PL- Consultation- WSCC Public Rights of Way response

CM/6/26/PL

From: Darryl Hobden [REDACTED]
Sent: 04 June 2026 11:18
To: Planning.Responses <Planning.Responses@arun.gov.uk>
Subject: WSCC PRoW Response to CM-6-26-2 Caravan Storage Church Farm, Climping - OBJECTION

AS EXISTING-
SITE LAYOUT

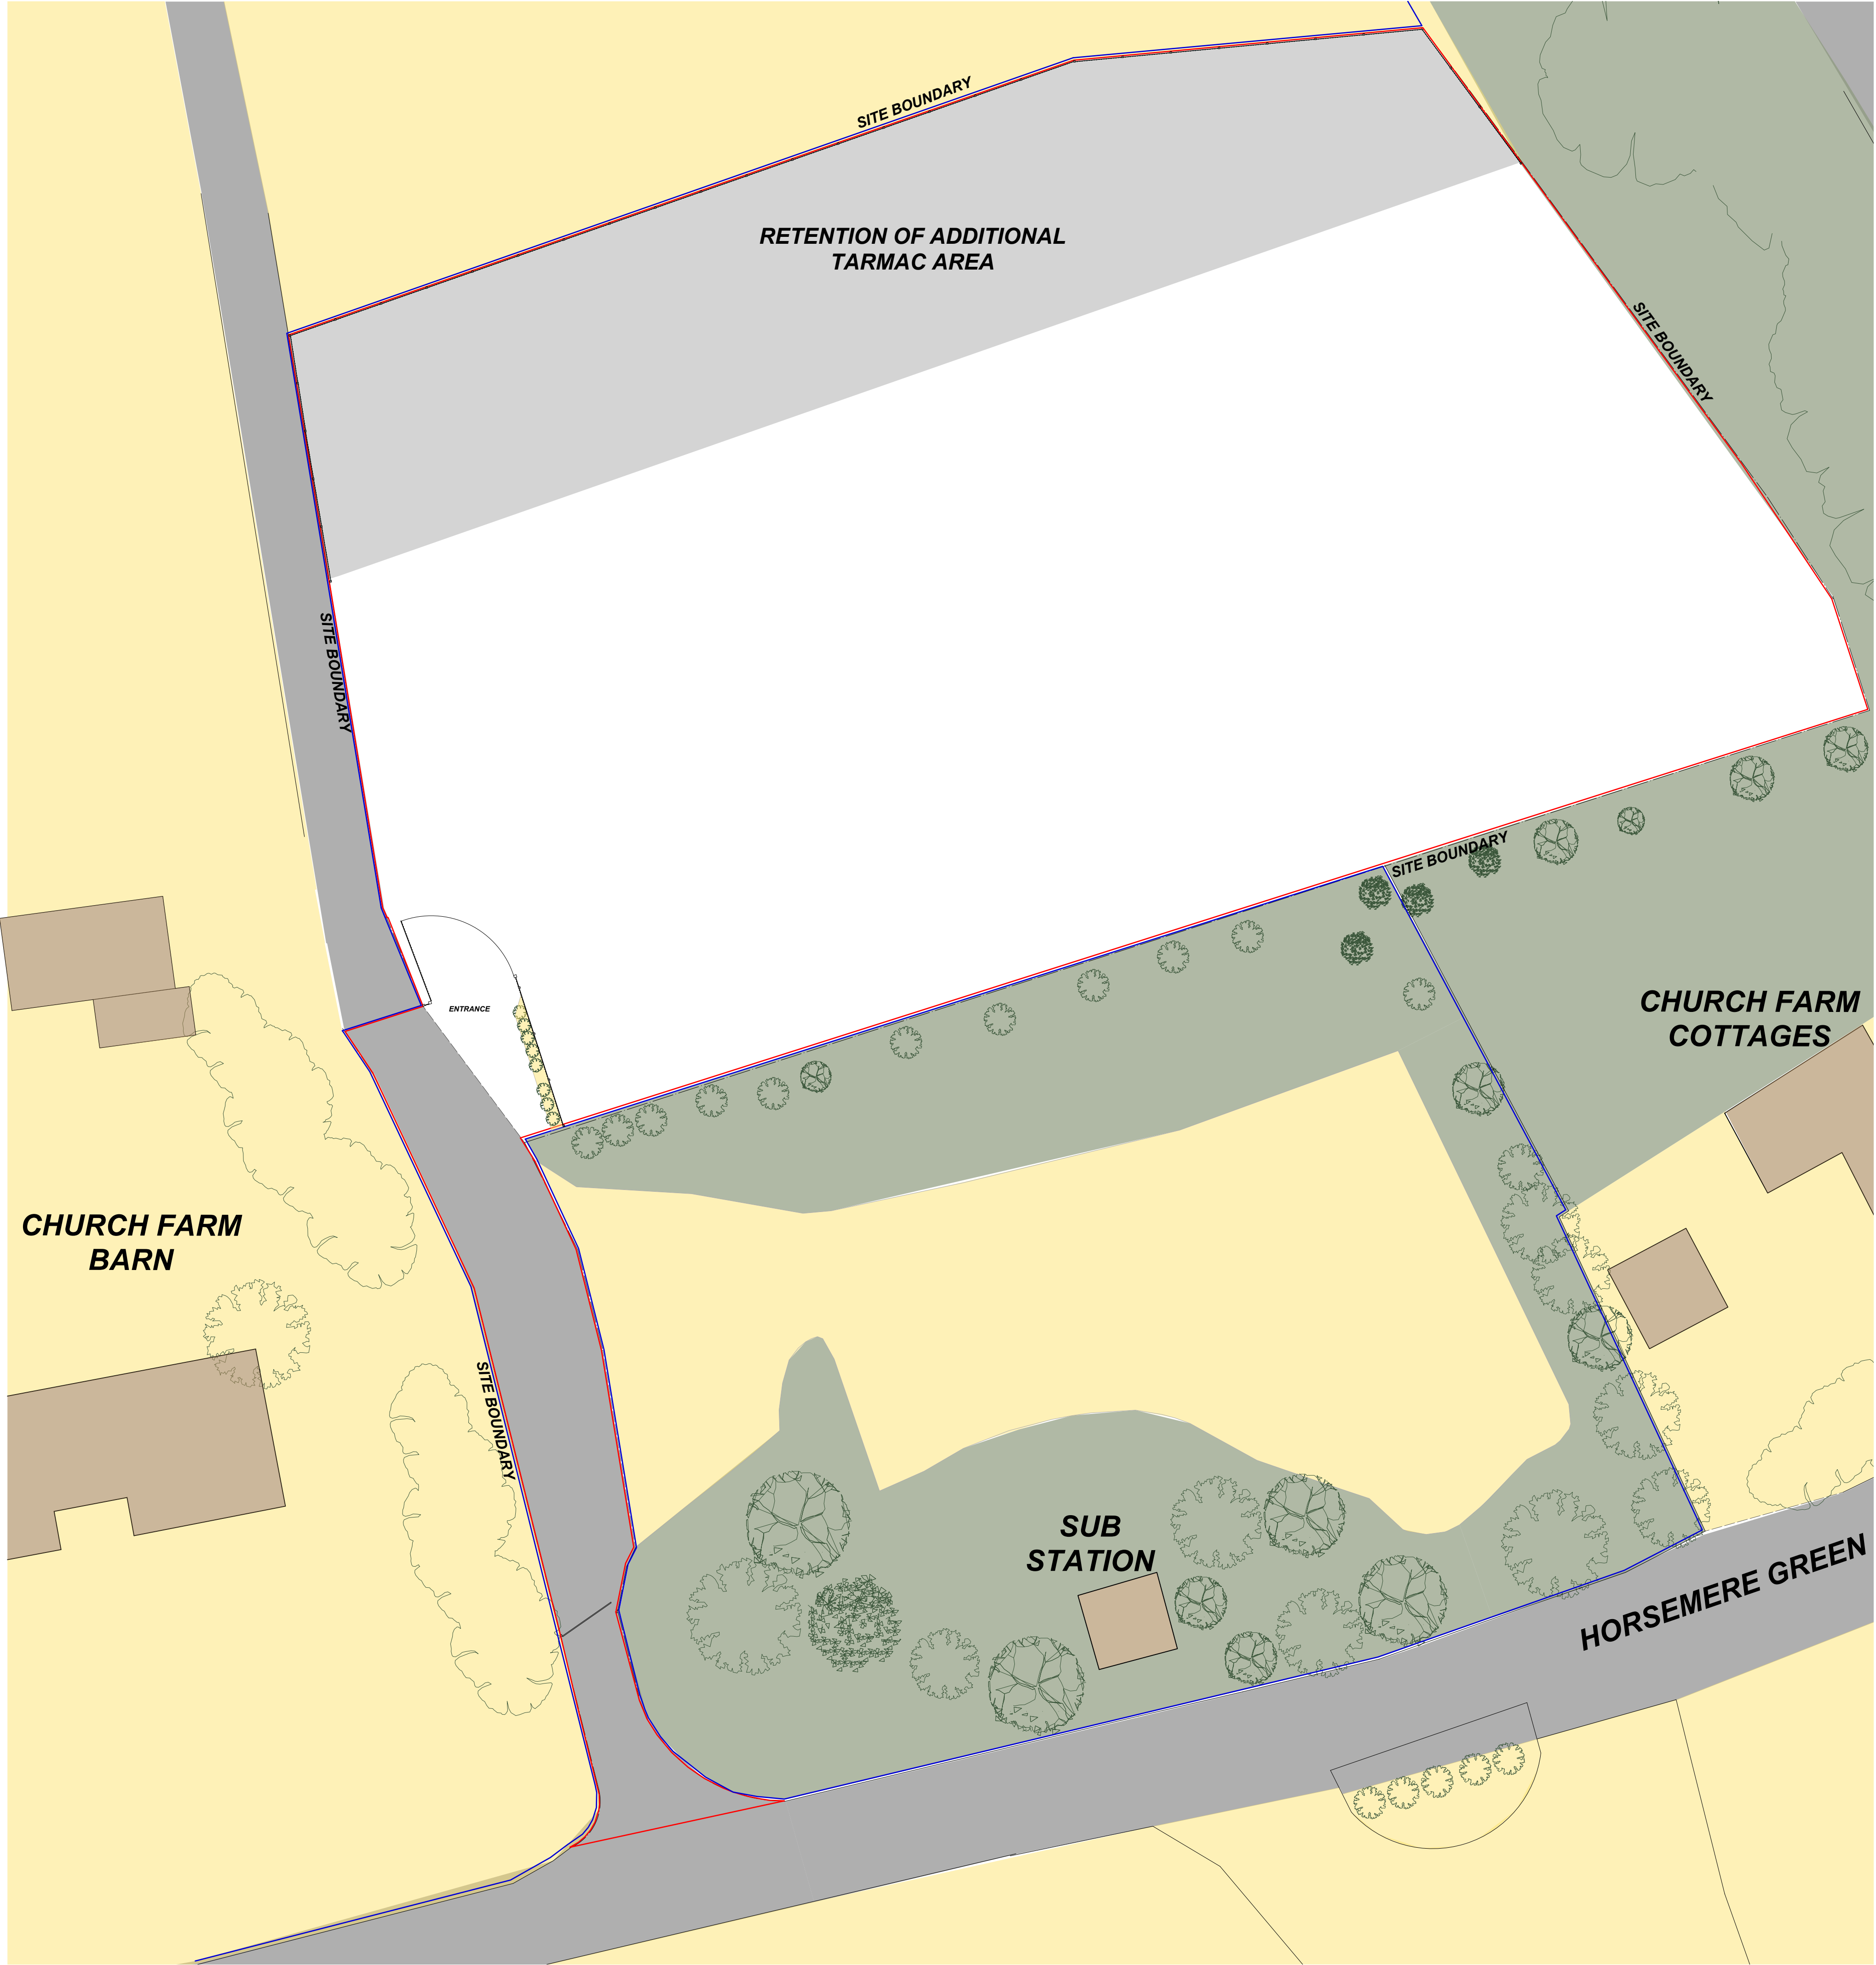
WSCC as Highway Authority formally objects to this proposal until such time that a detailed plan regarding Footpath 174 across the site is presented.
